DRB CASE ACTION LOG
(Preliminary/Final Plat)

DRB Application No.: 10DRB-70200

Project # 1008219

Project Name: *Hinton*

PLAT OF
LOT 21-A,
HINTON'S SUBDIVISION

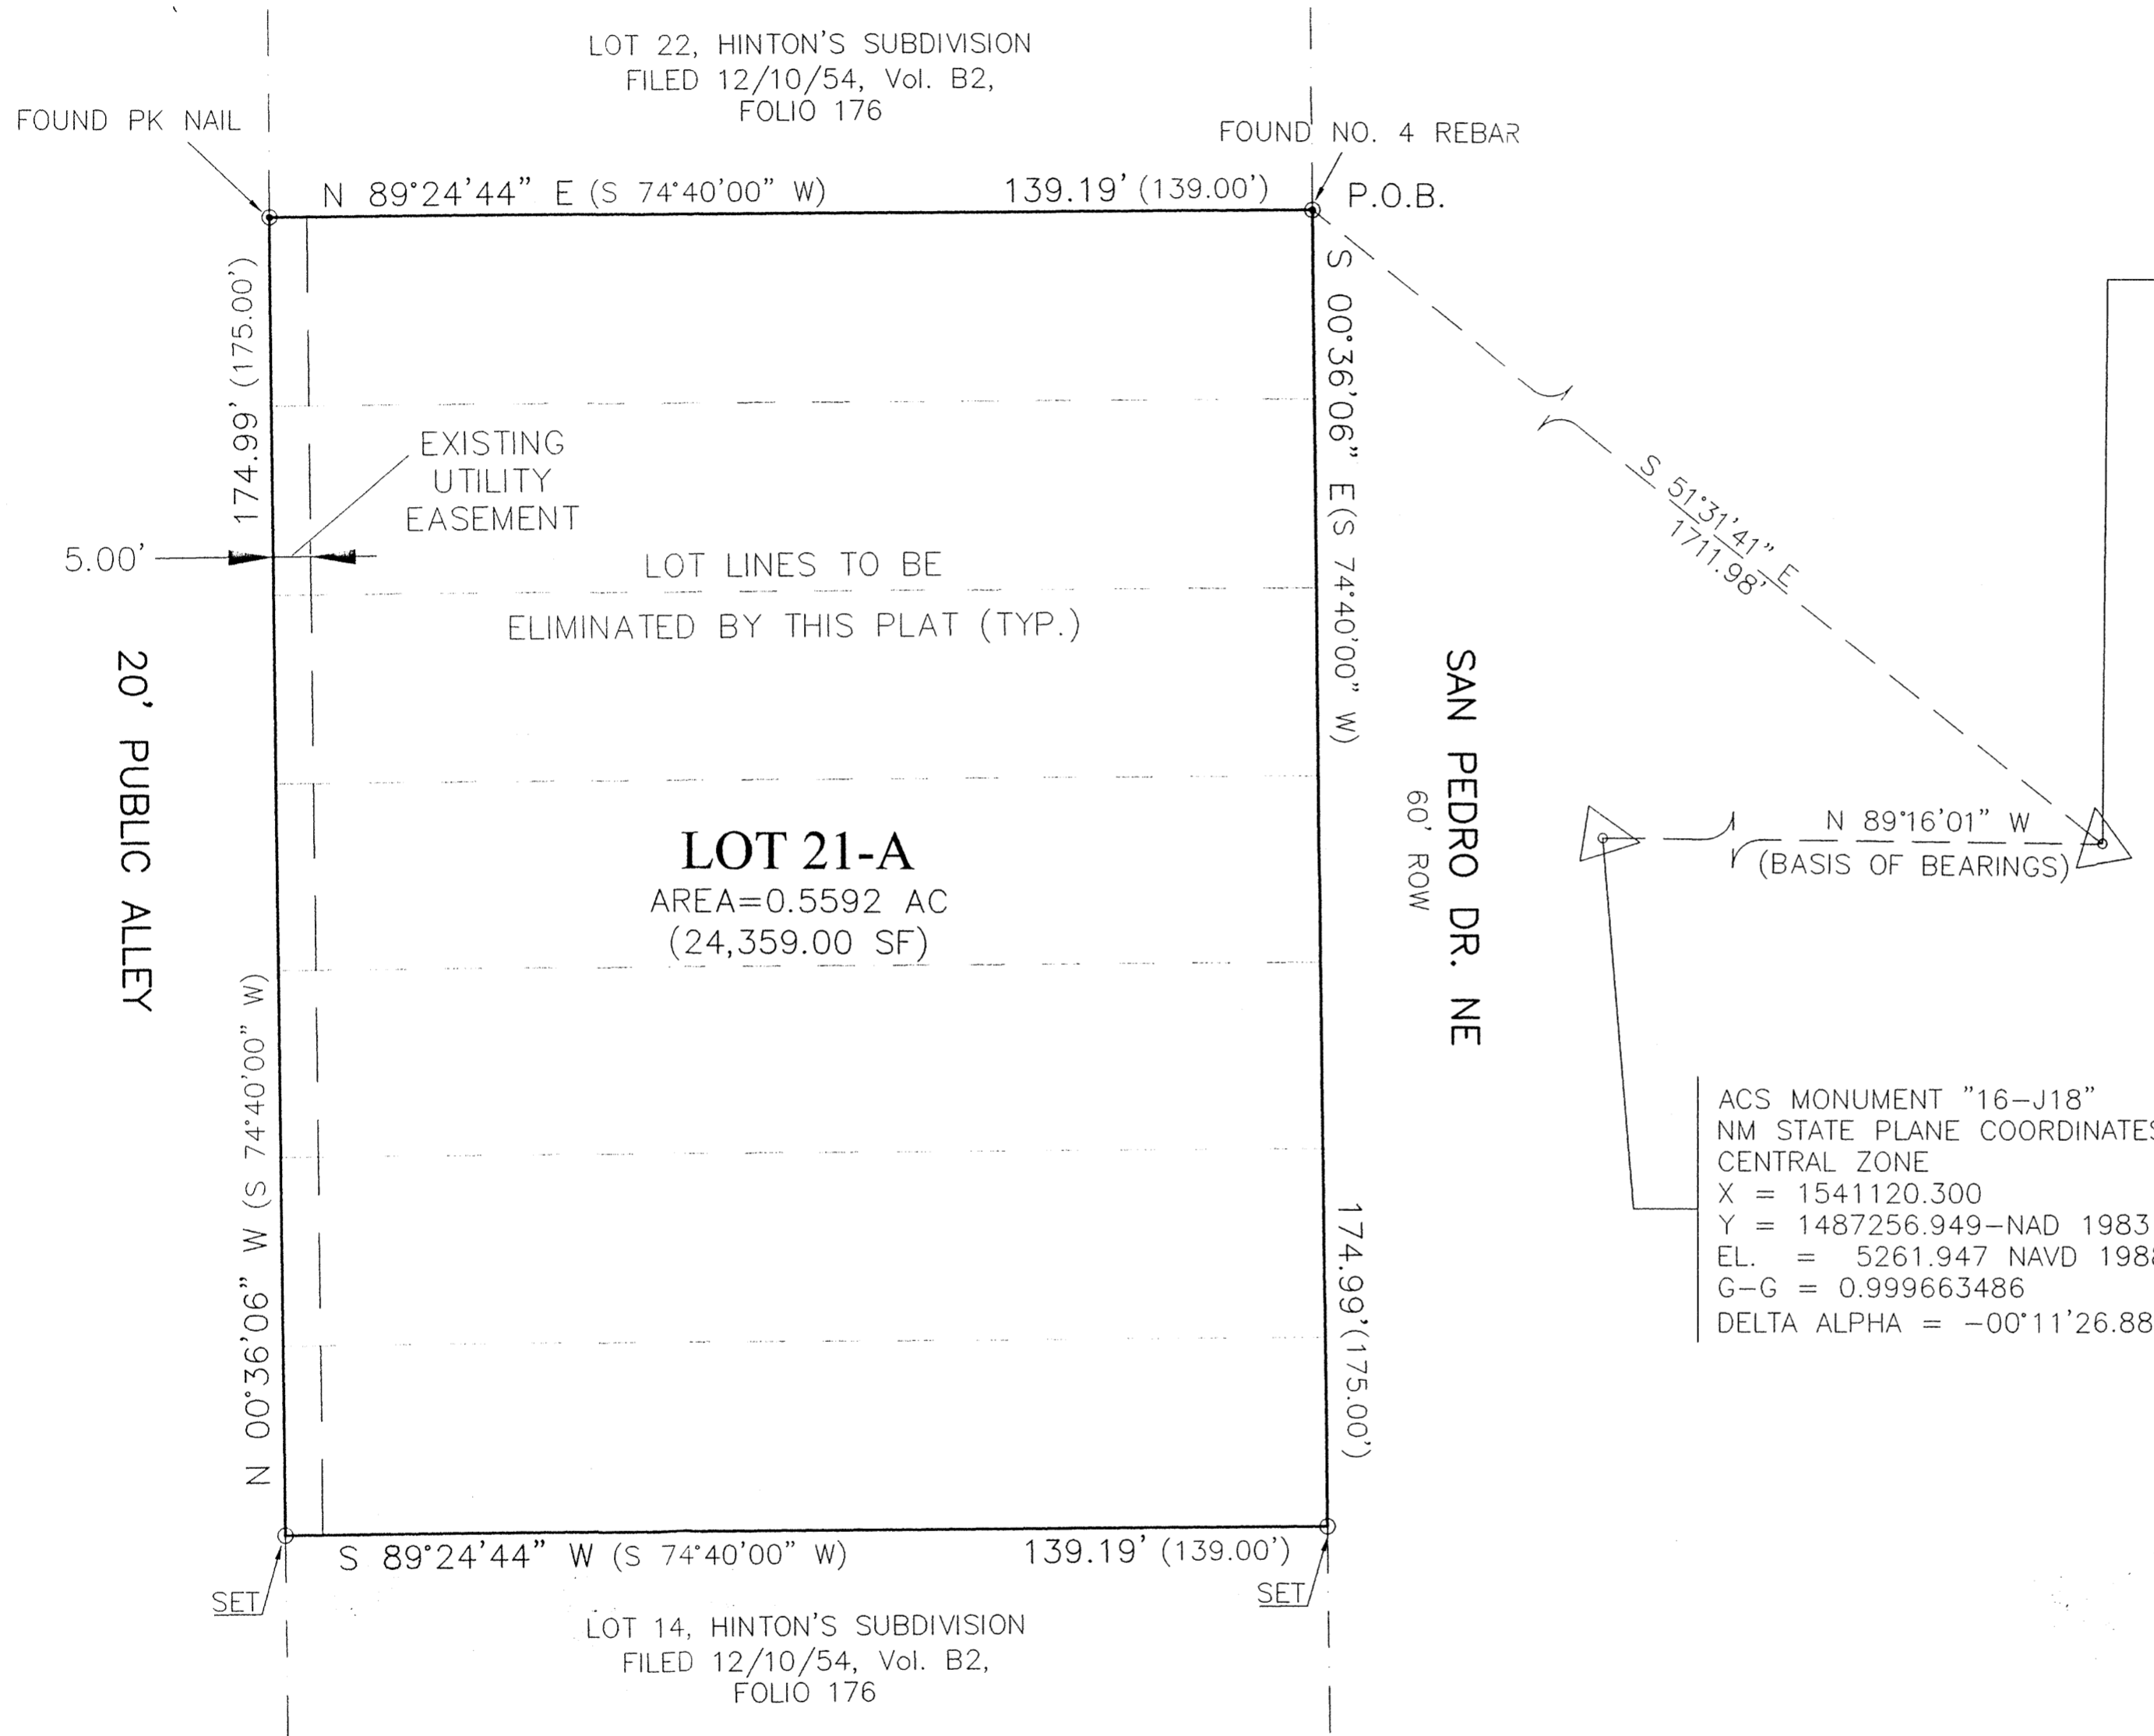
TRANSPORTATION: *- exhibit with dimensions*

This site is part of a "premise" which means these lots are being used to meet certain zoning requirements for the adjacent property with the building, such as parking and circulation – it appears reciprocal easements would be needed on a plat (e.g. parking, access, and drainage).
